SHOWGROUND PRECINCT EAST

3 ANDALUSIAN WAY, CASTLE HILL

DESIGN EXCELLENCE ADDENDUM REPORT

STATE SIGNIFICANT DEVELOPMENT APPLICATION

Figure 15: Amended SSDA scheme showing removal of lower ground floor basement underneath the publicly accessible pedestrian link

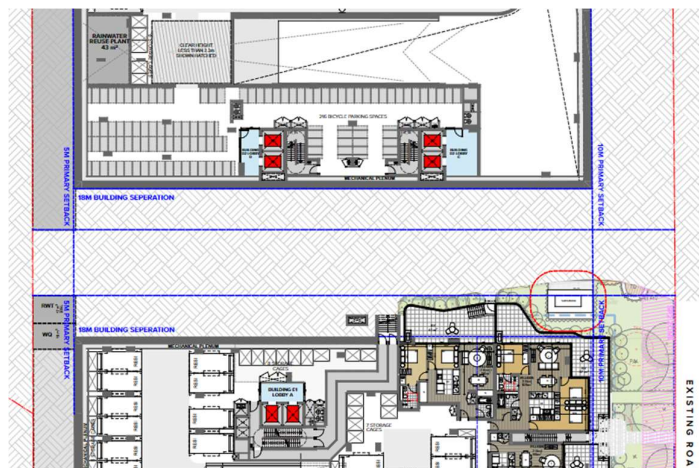
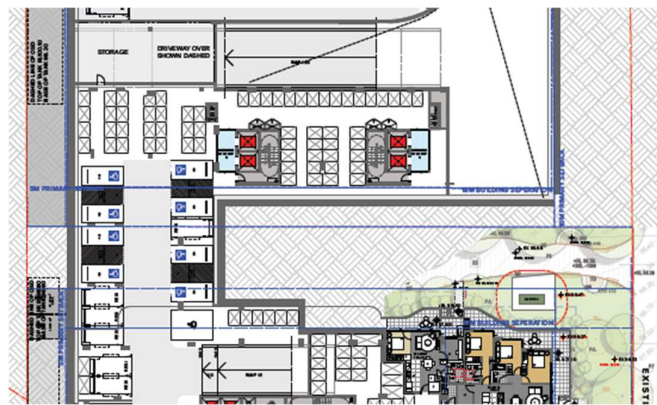
- c. Provide dimensioned drawings of deep soil, including basement car-parking layouts.
- d. Explore reconfiguring the basements beneath the publicly accessible pedestrian link to deliver genuine deep soil, connected to the wider soil structure.
- e. Where on structure, create generous soil volumes to ensure meaningful ecological outcomes and canopy can be achieved.
